Subject: FW: Ditch Infilling - Toddington Ditch IDB

Subject: Ditch Infilling - Toddington Ditch IDB

Further to our site meeting and inspection on 01 February 2019 (Mssrs Jackson and Moffatt [EA], Persimmon Homes and Meyer Brown Consultants), it has been acknowledged that works have been undertaken without the prior approval and consent of the River Arun Internal Drainage Board (whom the Environment Agency act as agents) It should therefore be noted that the ditch infilling and associated works are deemed to be 'unconsented'. Furthermore we do not issue or approve retrospective works.

WEST OF WEILANDS CATCHMENT - WATERCOURSES/HEADWALL AFFECTED

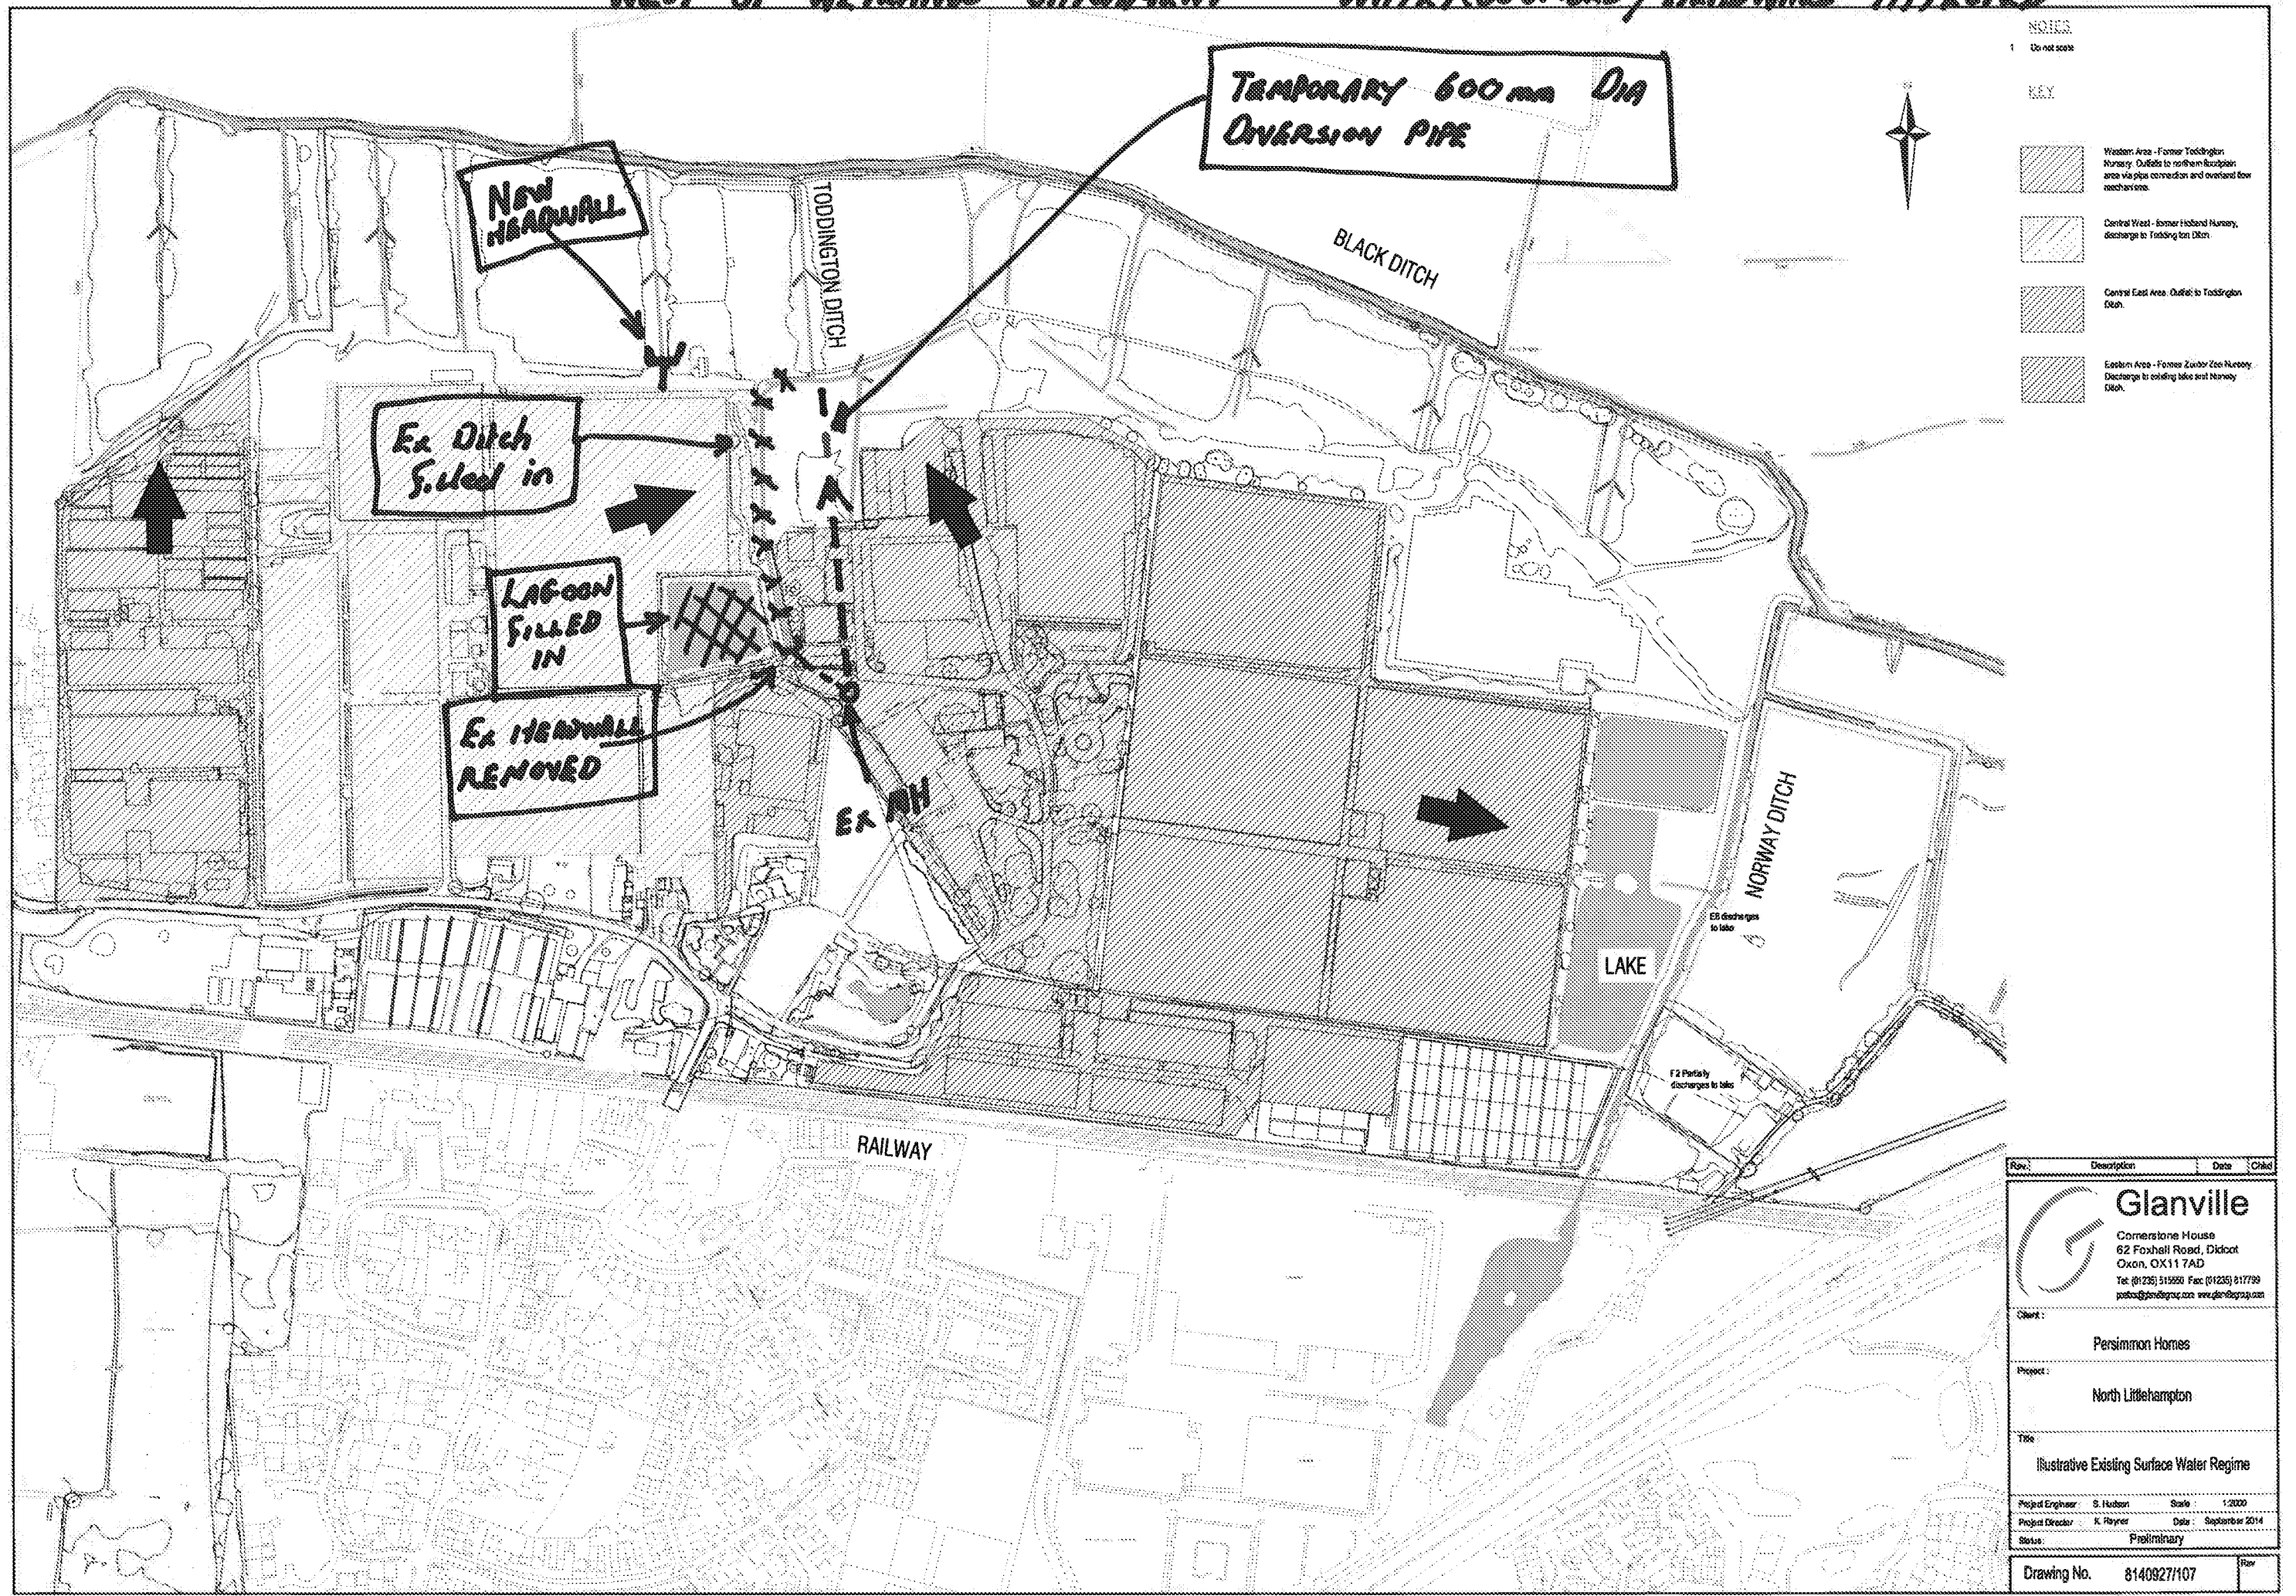
From an ecological perspective whilst a section of watercourse has been lost, the longer term benefit of the proposed wetland areas will compensate for the ditch loss.

With regards to the structure referred to as 'Headwall B' we are satisfied with the initial installation, but would reserve judgement, until the final landscaping works have been complete.
